RE: Bubba's 33
10000 Coors Bypass NW
Grading and Drainage Plan
Engineer's Stamp Date: 04/14/21
Hydrology File: B14D004H

Based upon the information provided in your resubmittal received 04/19/2021, the Grading & Drainage Plan is approved for Building Permit.

To City of Albuquerque	Project: Bubba's 33 – Albuquerque, NM
Attn: Renée C. Brissette	
Senior Hydrology Engineer	Re: Grading and Drainage Plan Review Comments
505-924-3995	
rbrissette@cabq.gov	Hydrology File: B14D004H

**C6.0**

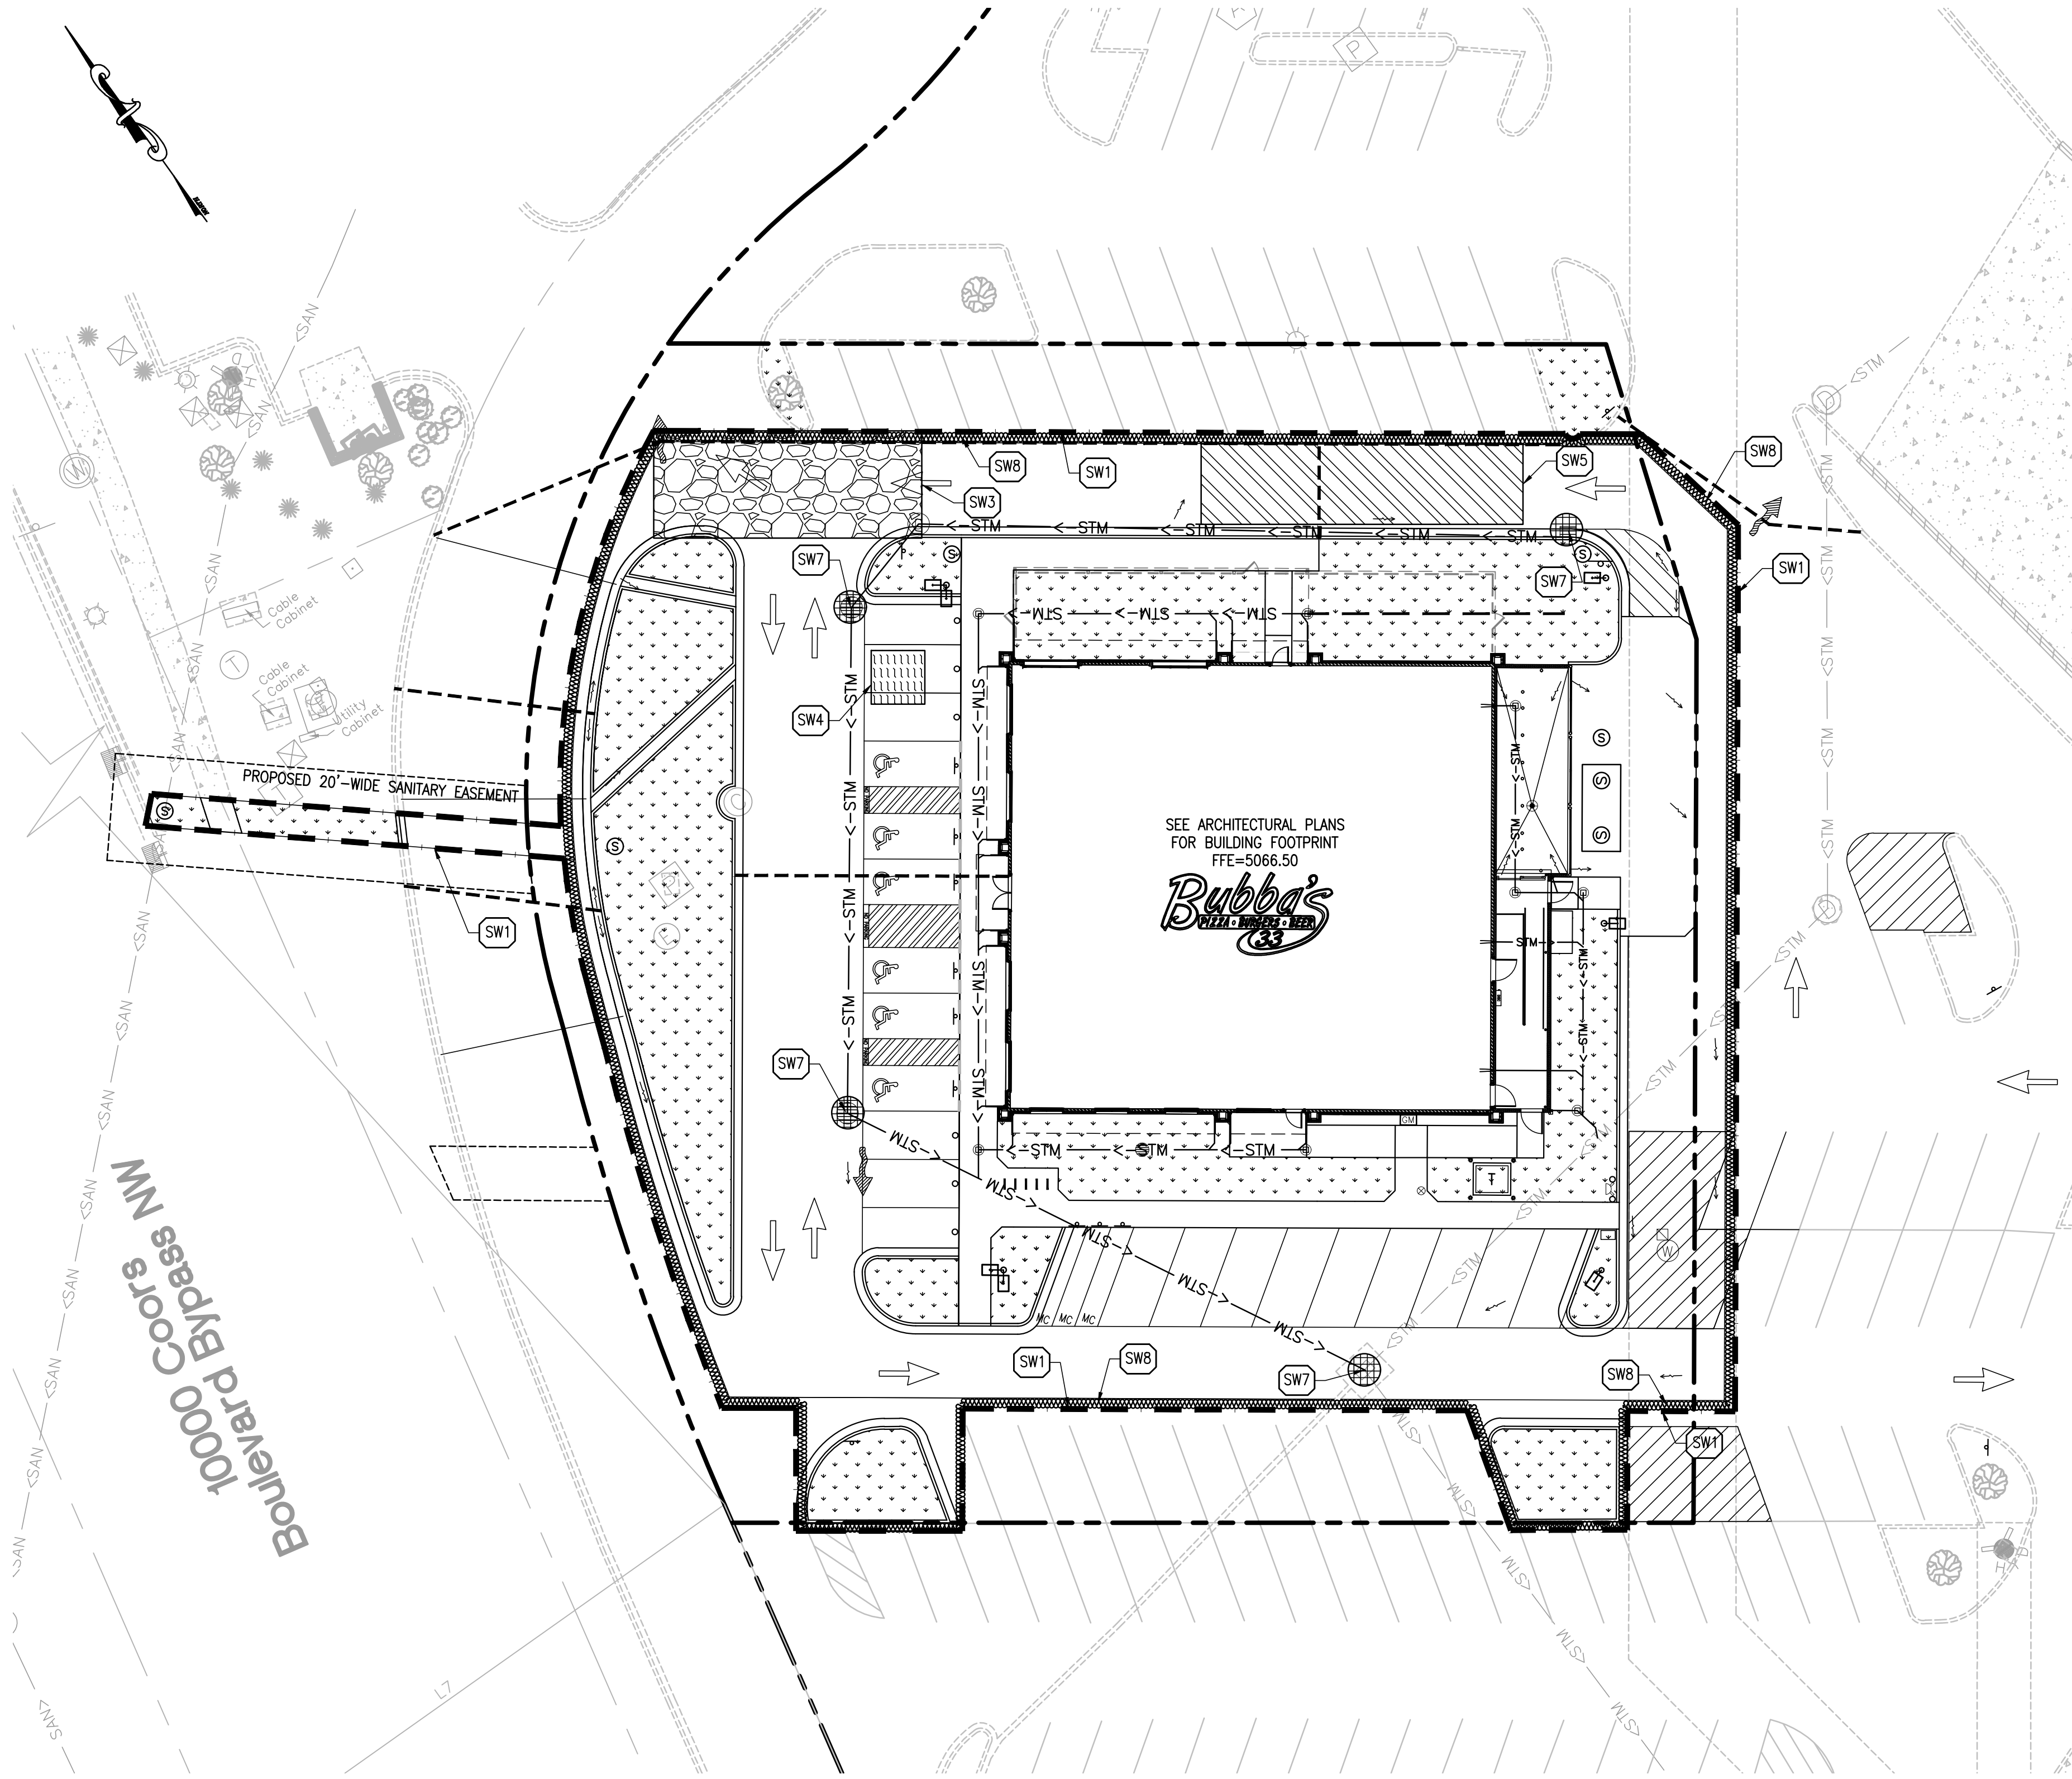
2. Provide management onsite for the Stormwater Quality Volume (SWQV) in accordance with the new drainage ordinance, § 14-5-2-6 (H) enacted 10/2/18 (Council Bill C/S O-18-2) and as outlined in DPM (signed 06/08/20) Article 6-12 Stormwater Quality and Low-Impact Development for the sizing calculations. Since this site is a redevelopment the SWQ pond volume will be $0.26 * \text{new impervious area (new paving, sidewalks, and building) (sf)} * 1/12$. If you are planning to provide for the SWQ volume, please show the top and bottom of the ponds along with the volume for each pond within the landscape areas. The onsite drainage should be directed to these ponds via curb cuts prior to either being collected in the existing inlet or leaving the site for the public drainage system. If you are going to not provide for the SWQ volume within the landscape areas, then you will need to add a statement, "The Owner has elected to pay for the Stormwater Quality Volume. The Payment-in-lieu will be $\$8 / CF * SWQ \text{ volume (CF)} = \$ XX$."

4. As a reminder, if the project total area of disturbance (including the staging area and any work within the adjacent Right-of-Way) is 1 acre or more, then an Erosion and Sediment Control (ESC) Plan and Owner's Certified Notice of Intent (NOI) is required to be submitted to the Stormwater Quality Engineer (Doug Hughes, PE, jhughes@cabq.gov, 924-3420) 14 days prior to any earth disturbance.

Response: Due to limited pervious areas and the pervious areas mostly residing on existing easements, we will be unable to provide SWQ volume on the site. The Stormwater Quality Volume and payment calculations/statement have been added the C6.0 Stormwater Pollution Prevention Plan.

Response: We are disturbing 0.88 acres so we are currently under the 1 acre limit. See the C6.0 Stormwater Pollution Prevention Plan.
